WEST SUSSEX COUNTY COUNCIL CONSULTATION

TO:	Arun District Council FAO: Anita Gardner
FROM:	WSCC - Highways Authority
DATE:	30 October 2020
LOCATION:	13 Elm Drive Elmer Middleton-On-Sea PO22 6JE
SUBJECT:	M/75/20/PL Demolition of existing dwelling & erection of replacement dwelling. This site is in CIL Zone 4 & is CiL Liable as new dwelling,
DATE OF SITE VISIT:	n/a
RECOMMENDATION:	Advice
S106 CONTRIBUTION TOTAL:	n/a

This application is for demolition of existing dwelling and erection of replacement three bedroom dwelling. The site is located on Elm Drive, a privately maintained road, therefore these comments are for advice only. Elmer Road is the nearest publicly maintained highway.

Site Plan 1:100

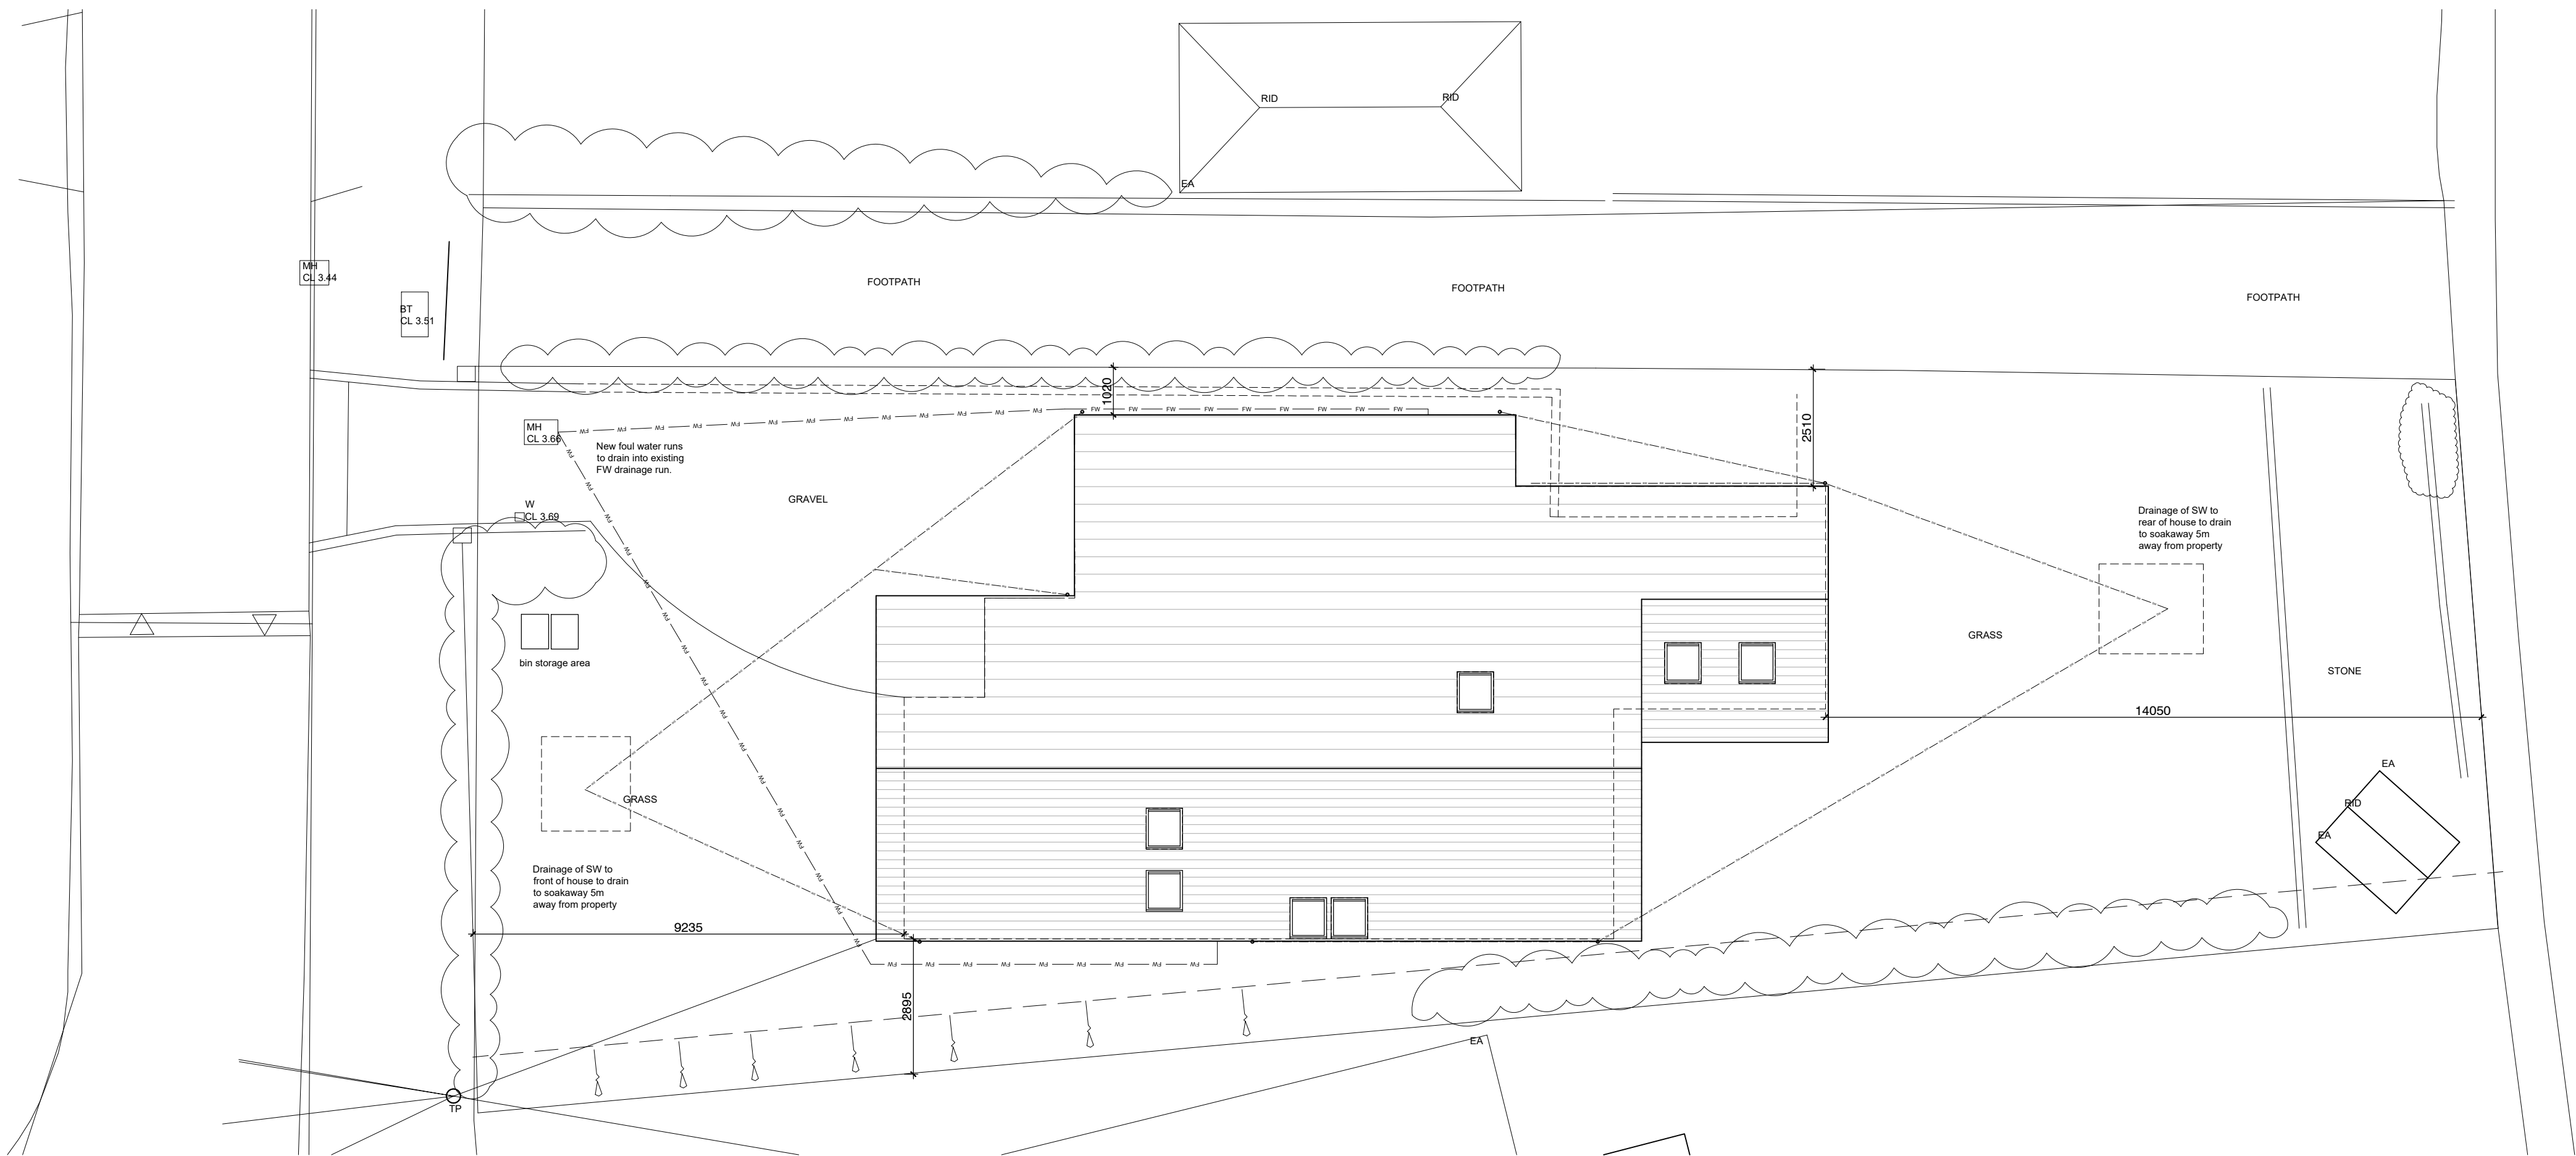
The proposed plans indicate that a garage and off-street parking will be provided for the dwelling. The garage meets minimum specifications of 3 x 6m as set out in Manual for Streets. At least two vehicles can be parked on the proposed gravel driveway. A turn on site is not provided, however the LHA would not raise any highway safety concerns to this arrangement as it is anticipated that vehicles will exit onto the publicly maintained highway in a forward gear.

The site is sustainably located within walking distance of local amenities and bus stops. Cycling is a viable option within the vicinity and cycle storage should be provided for the proposed dwelling to encourage sustainable transport methods. No details of cycle storage have been provided, however the LHA note that the proposed garage is of sufficient size to accommodate cycle storage for the dwelling. Details of secure and covered cycle storage can be secured via condition.

In the interests of sustainability and as result of the Government's 'Road to Zero' strategy for at least 50% of new car sales to be ultra-low emission by 2030, electric vehicle (EV) charging points should be provided for all new homes. The applicant is advised that for dwellings with an off-street parking provision, 100% of parking spaces should be provided with active EV parking spaces in accordance with the Arun Parking Standards (adopted January 2020). A suitably worded condition is advised below.

No part of the development shall be first occupied until the car parking has been constructed in accordance with the approved site plan. These spaces shall thereafter be retained at all times for their designated purpose.

No part of the development shall be first occupied until covered and secure cycle parking spaces have been provided in accordance with plans and details to be submitted to and approved by the Local Planning Authority.

No part of the development shall be first occupied until the electric vehicle charging space(s) have been provided in accordance with plans and details to be submitted to and approved by the Local Planning Authority.
